This note has been prepared by Swan Golf Designs in response to the comments made by Mr Dean Clayton (15<sup>th</sup> November 2021) and Mr Richard Topliss (16<sup>th</sup> November 2021), relating to the material submitted within an application to discharge a planning obligation (CDC Ref: 21/03164/OBL) associated with the planning permission for the Great Wolf Lodge waterpark and hotel (CDC Ref: 19/02550/FUL). The concerns raised in the aforementioned representations are dealt with in turn, with the comments in **bold italics** and our responses in blue.

**25<sup>th</sup> November 2021**

**DETAILED DESIGN
GREEN 3**

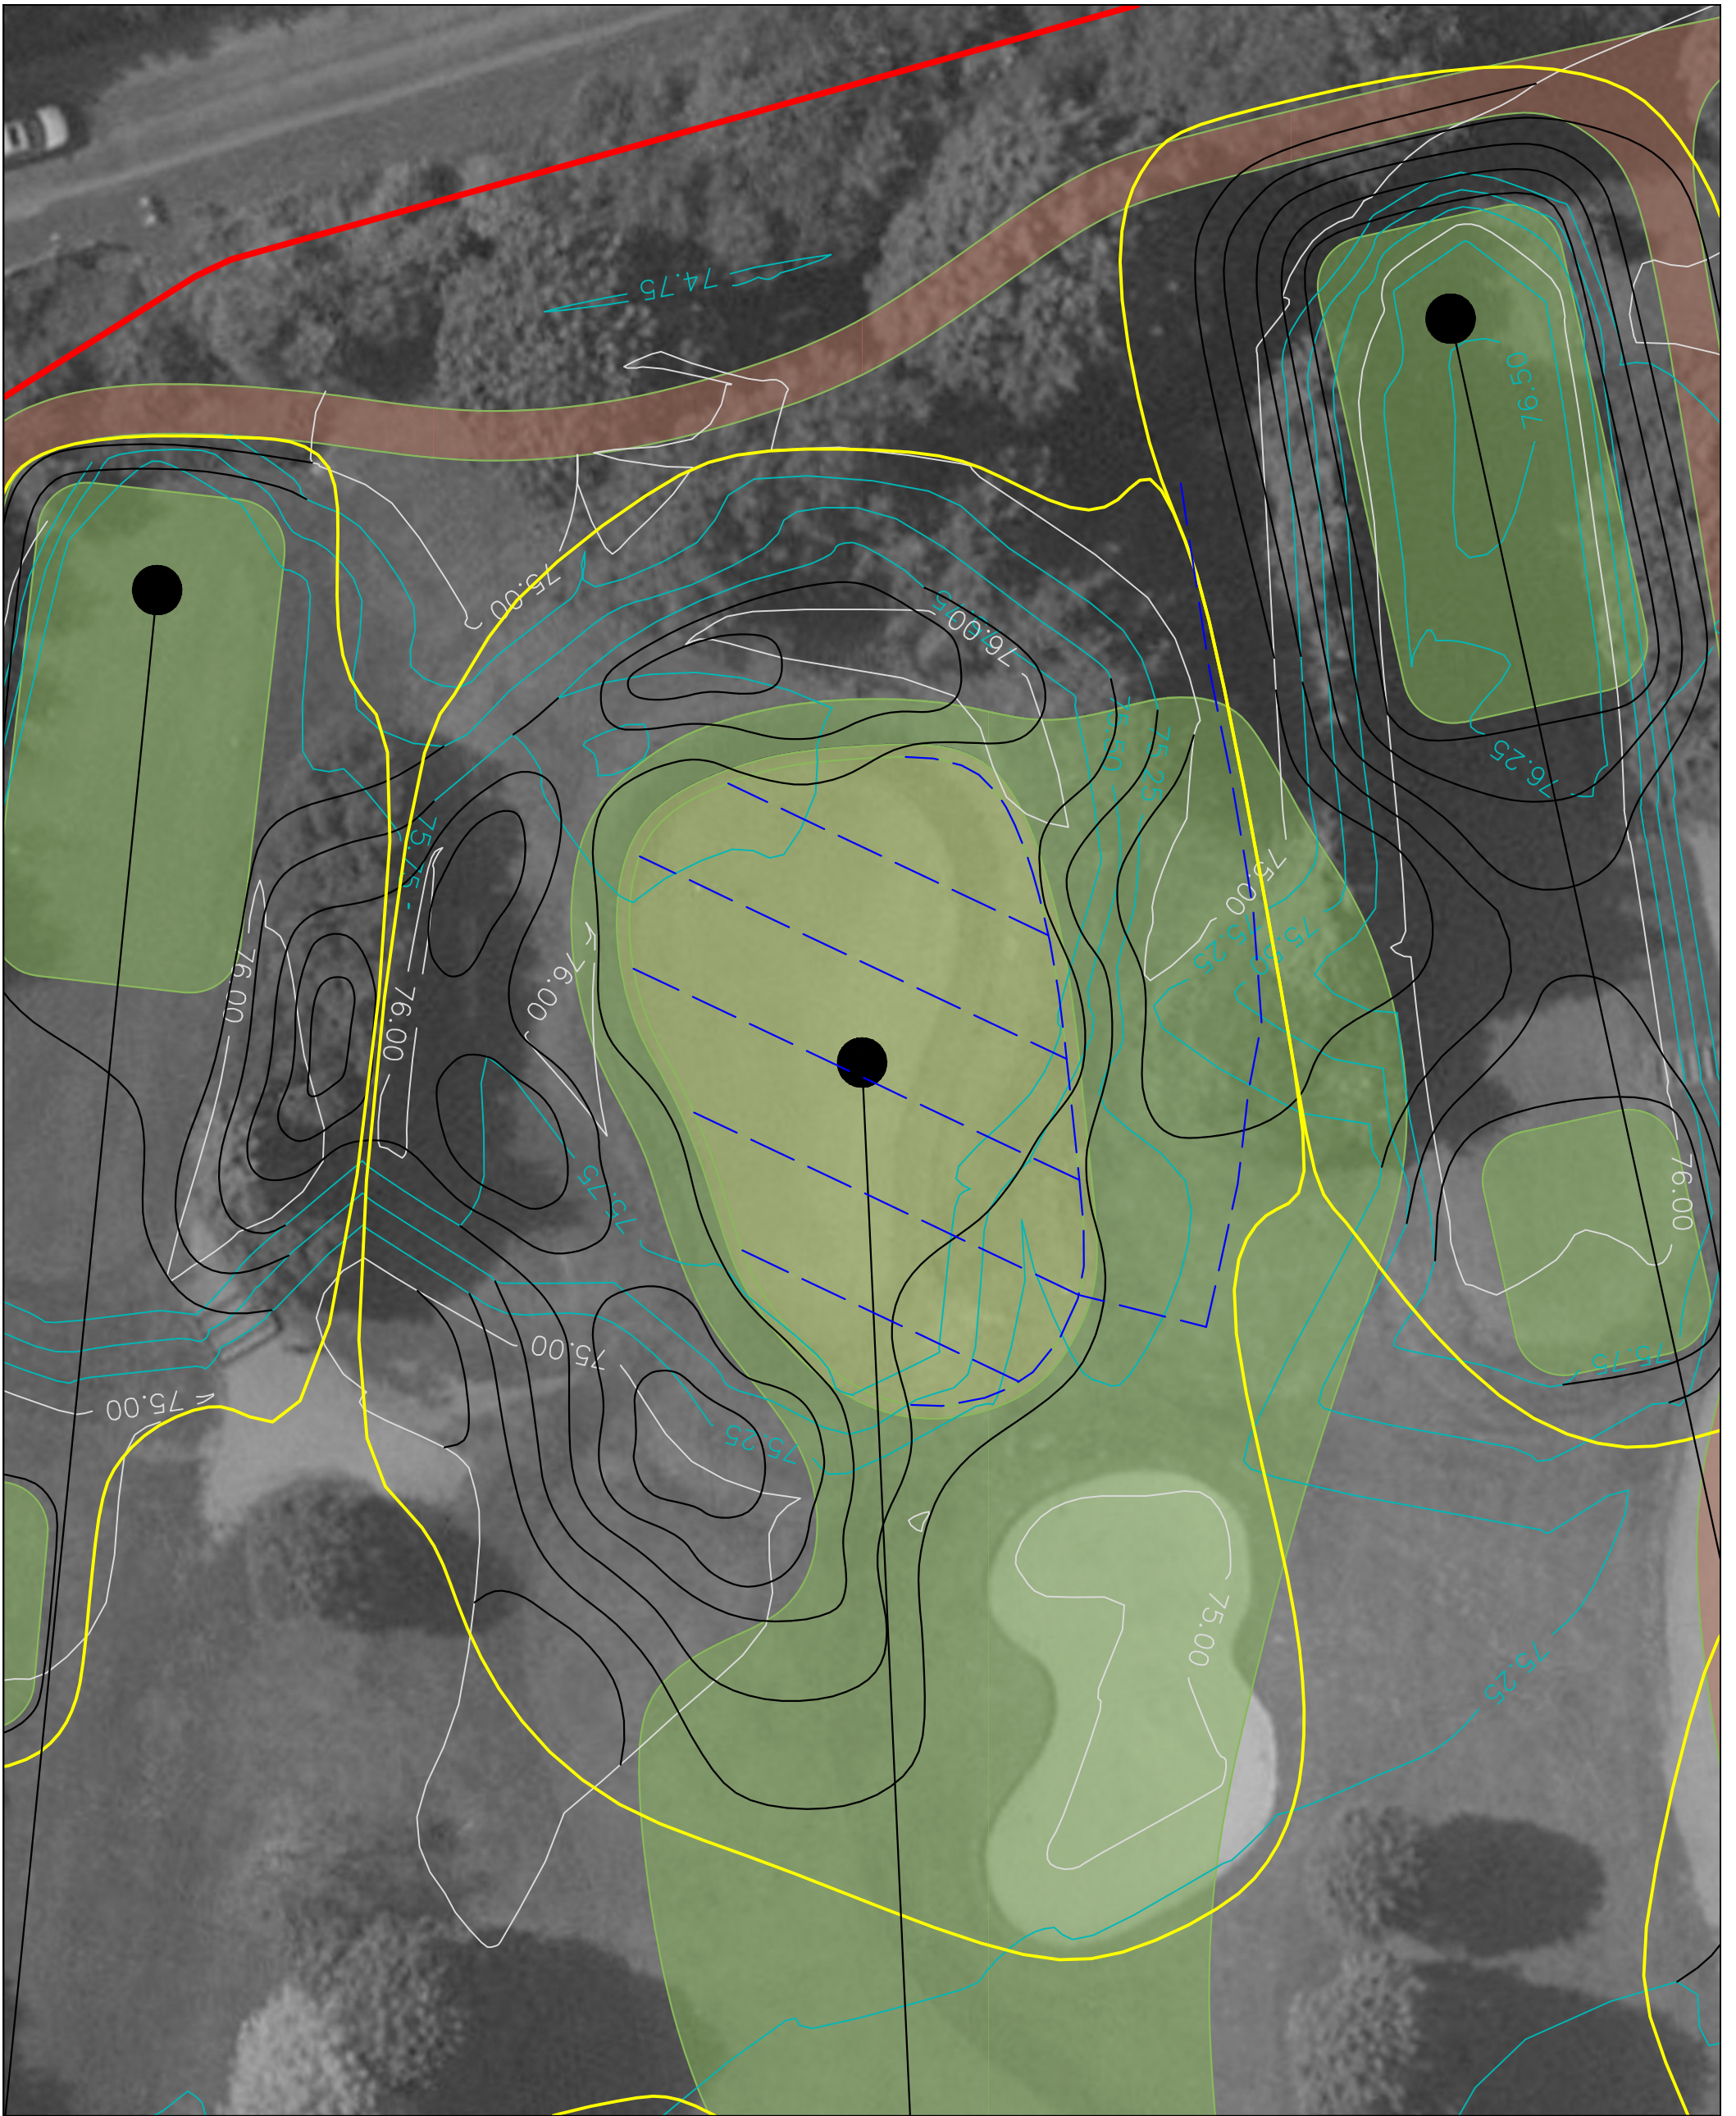
***Playability of the new 3<sup>rd</sup> green due to its proximity to water***

The new 3<sup>rd</sup> green is not adjacent to any water feature.
